From: Amanda Scholes on behalf of Planning.Responses
Sent: 06 April 2017 09:13
To: Planning Scanning
Subject: FW: The Gatehouse, Lidsey Road, ADC Ref: AL/9/17/DOC, Your Ref: PLAN-017219
Attachments: 05.04.17 PLAN-017802.pdf

Your Ref
AL/9/17/DOC
Our Ref
PLAN-017802
Date
05/04/2017

Proposal: Application for approval of matters reserved by condition imposed under AL/99/15/PL relating to condition no. 4 (Surface Water Drainage),5(Landscaping) & 9 (Foul Drainage).

Site: The Gatehouse, Lidsey Road, Aldingbourne, PO20 3ST.
AL/9/17/DOC

project	Residential development The Gatehouse. Lidsey Road. Woodgate		
detail	site levels as proposed		
drawn	sgr	checked	
date	09-15	status	Const.
a1 scale	1:50	a3 scale	1:100
	8590	rev	B

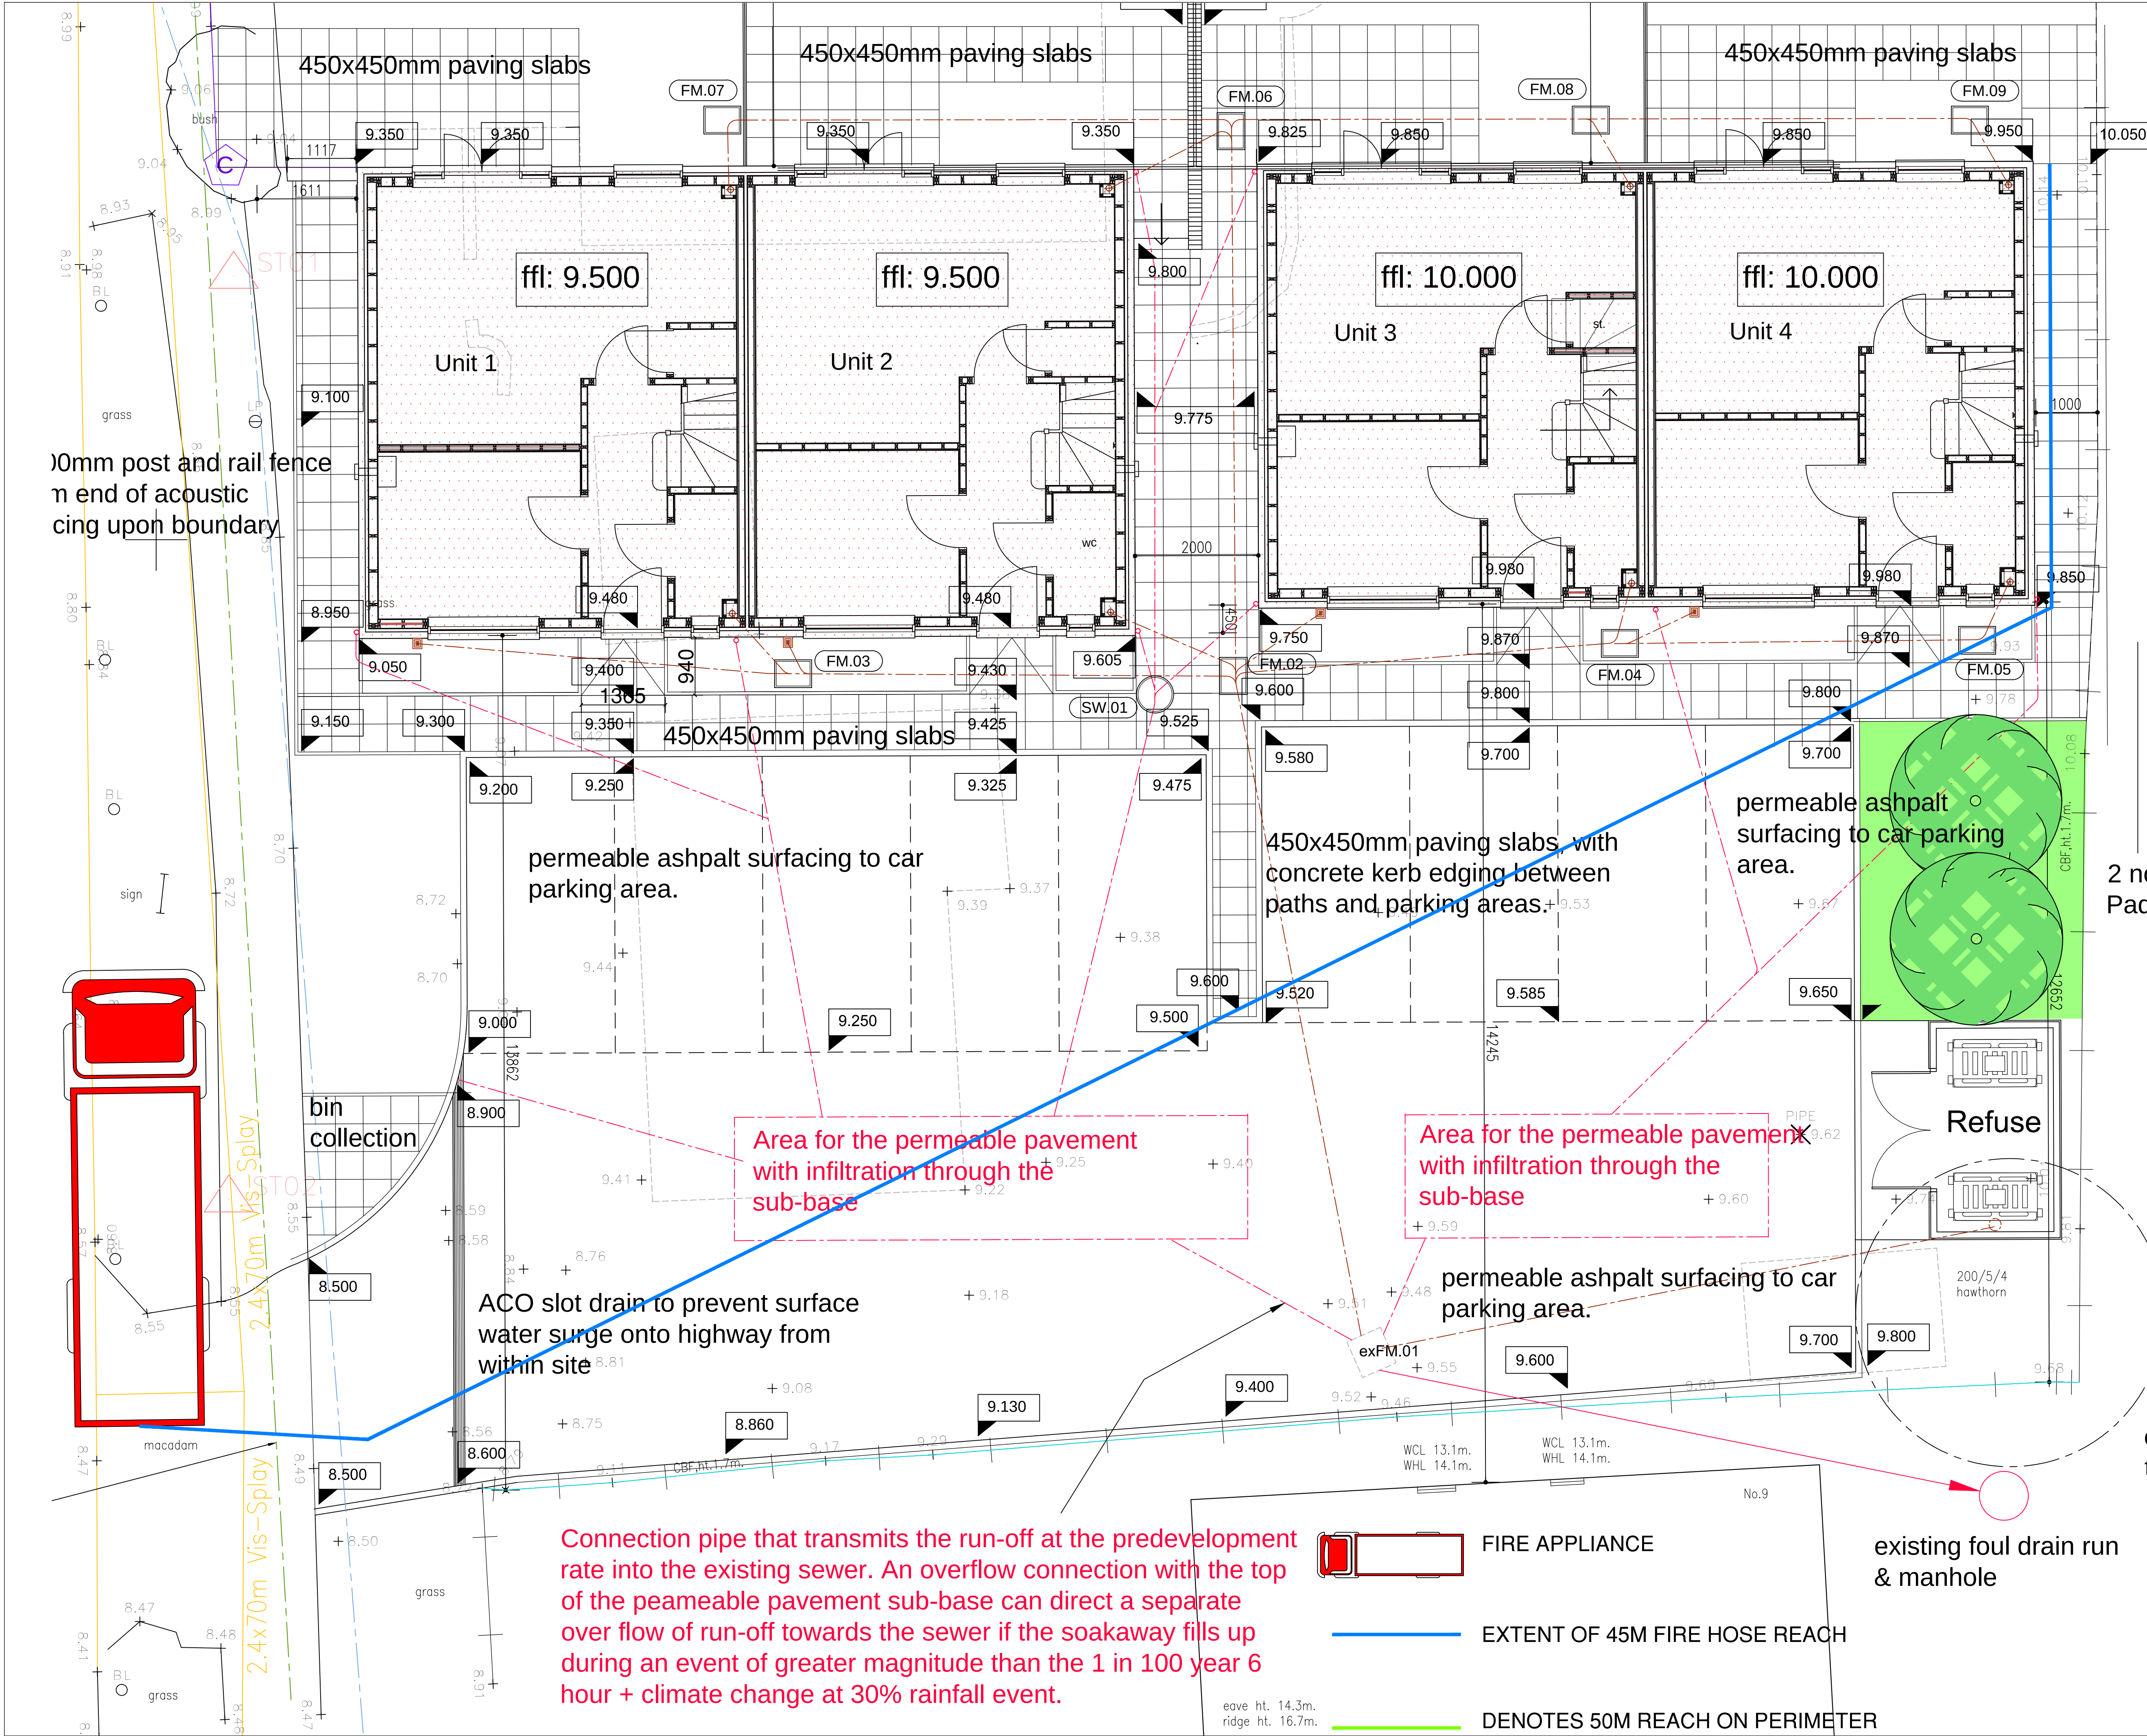
I think I see the problem. We have Drawing 8590-11B on our system which states that:

"Connection pipe that transmits the run-off at the predevelopment

rate into the existing sewer. An overflow connection with the top of the permeable pavement sub-base can direct a separate over flow of run-off towards the sewer if the soakaway fills up during an event of greater magnitude than the 1 in 100 year 6 hour + climate change at 30% rainfall event."

I assume then that 8590-10-B should replace 8590-11B? Please confirm.

That is correct, the submitted drawing takes precedence as it is not intended in any way to have the surface water connect into the existing foul system,

project	Residential development The Gatehouse, Lidsey Road. Woodgate		
detail	site layout plan		
drawn	sgr	checked	
date	09-15	status	Const.
a1 scale	1:100	a3 scale	1:200
		8590 10	rev B

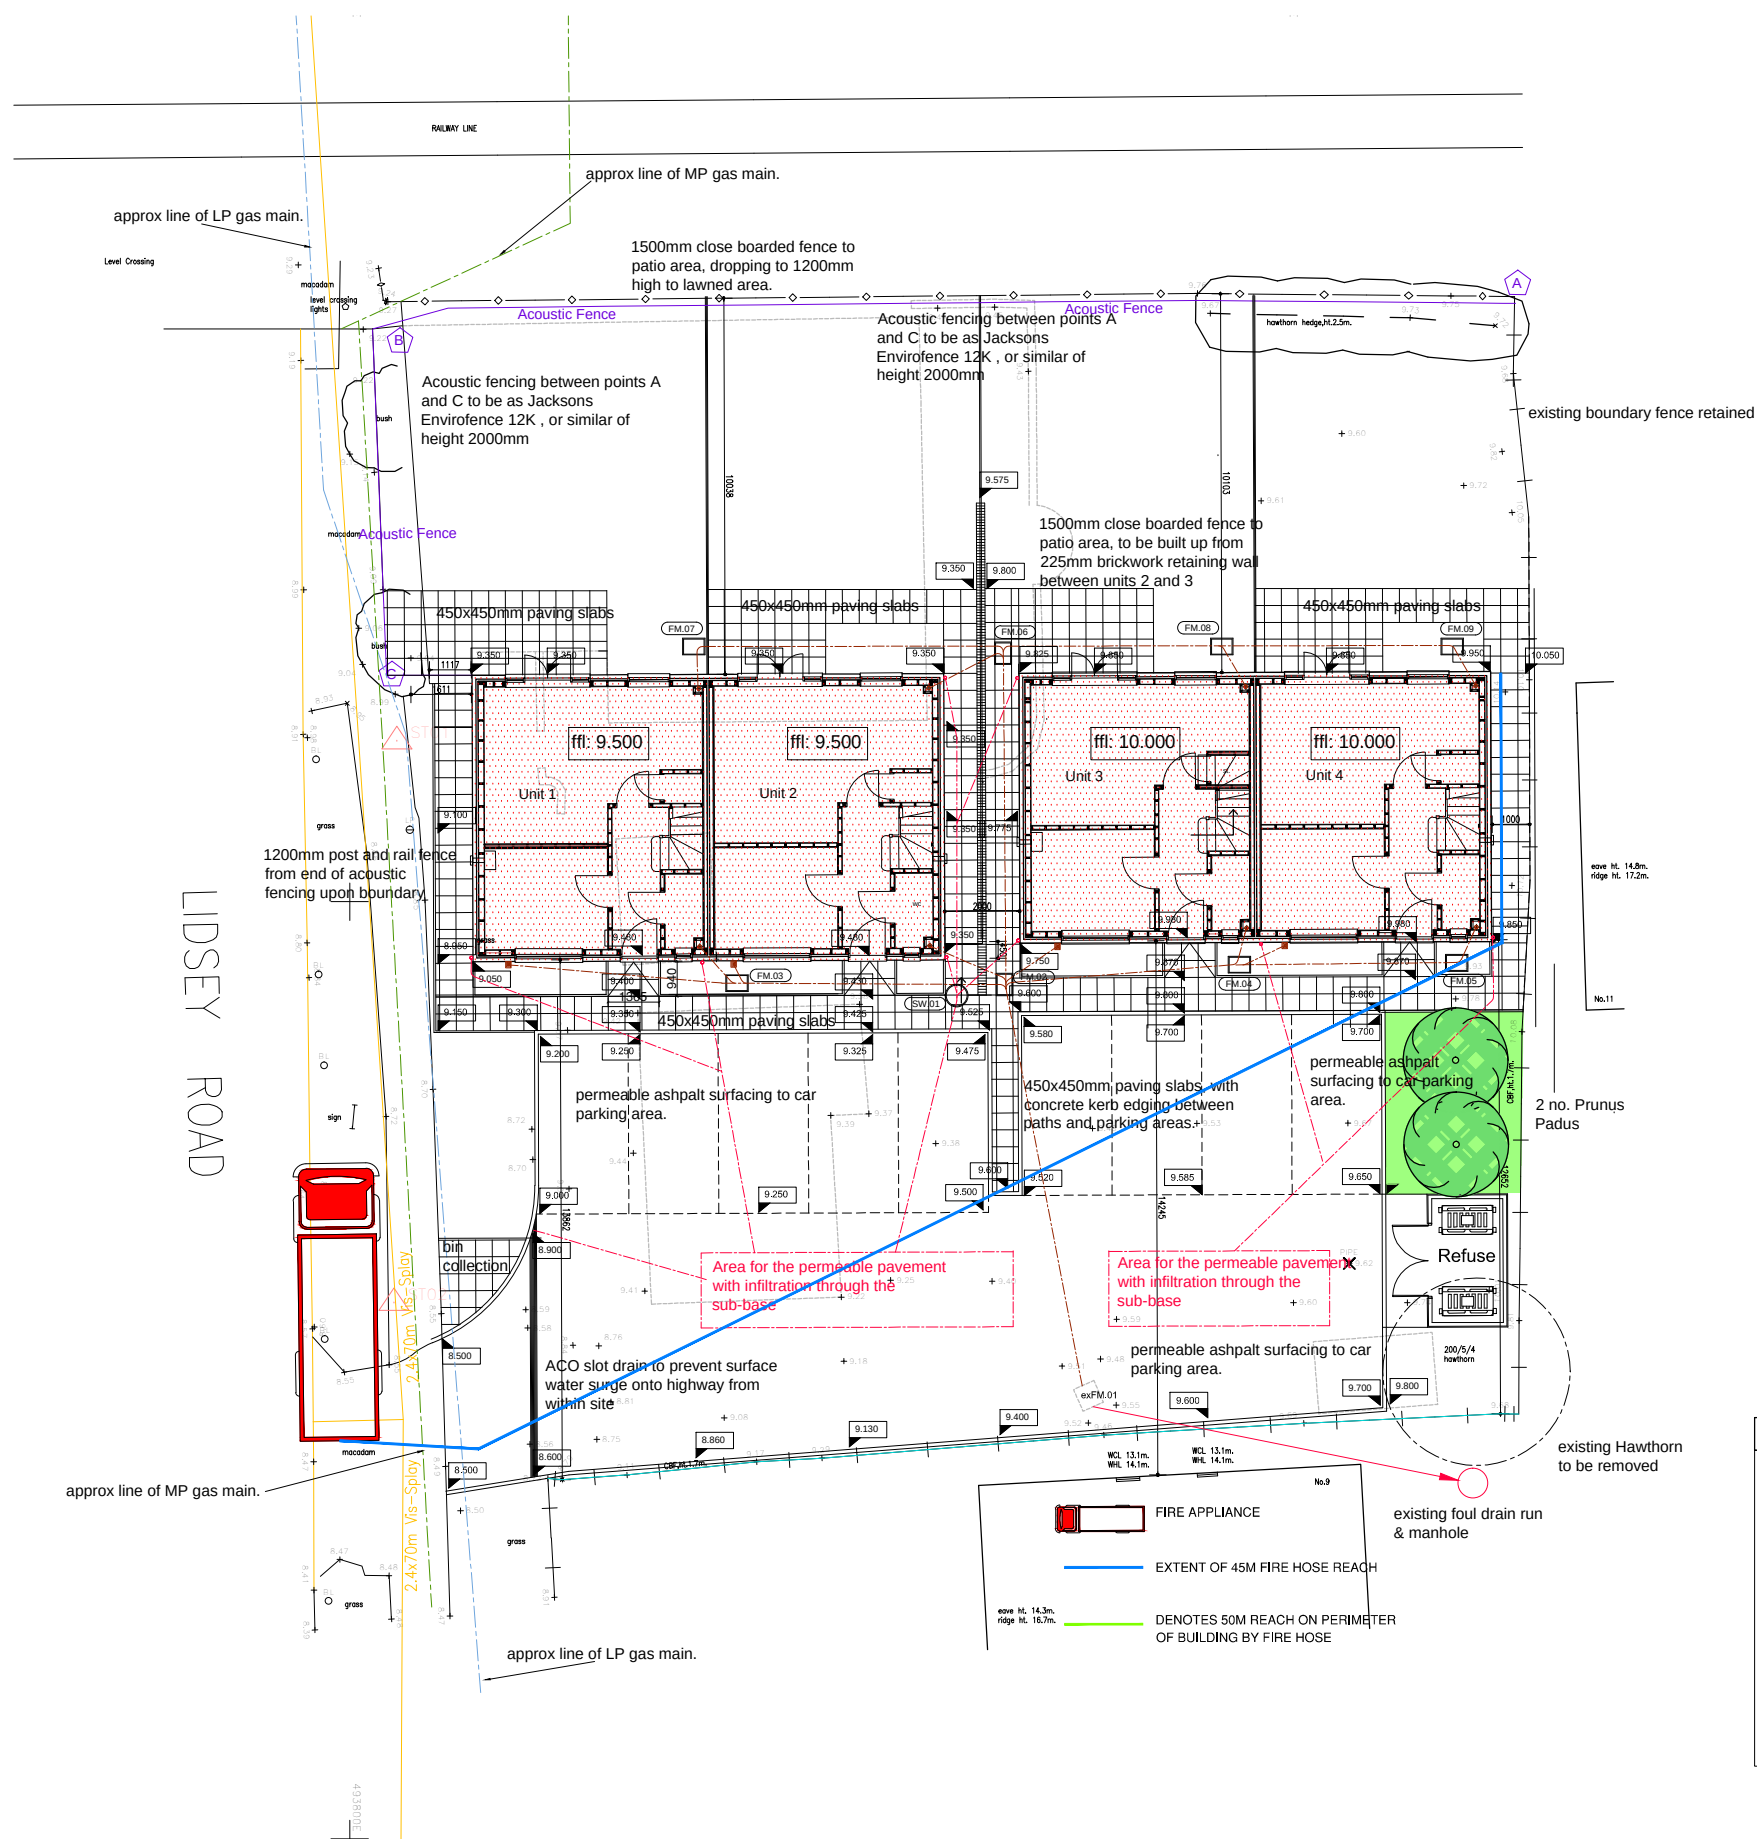
Southern Water would have no objections to discharge condition 9 relating to foul drainage. The acceptable drainage strategy is as shown on drwg Site Layout Plan 8590 10 Rev B. An approval for the connection to the public foul sewer should be obtained under Section 106 of the Water Industry Act. The design of drainage should ensure that no surface water run off, groundwater or land drainage is to enter public sewers.
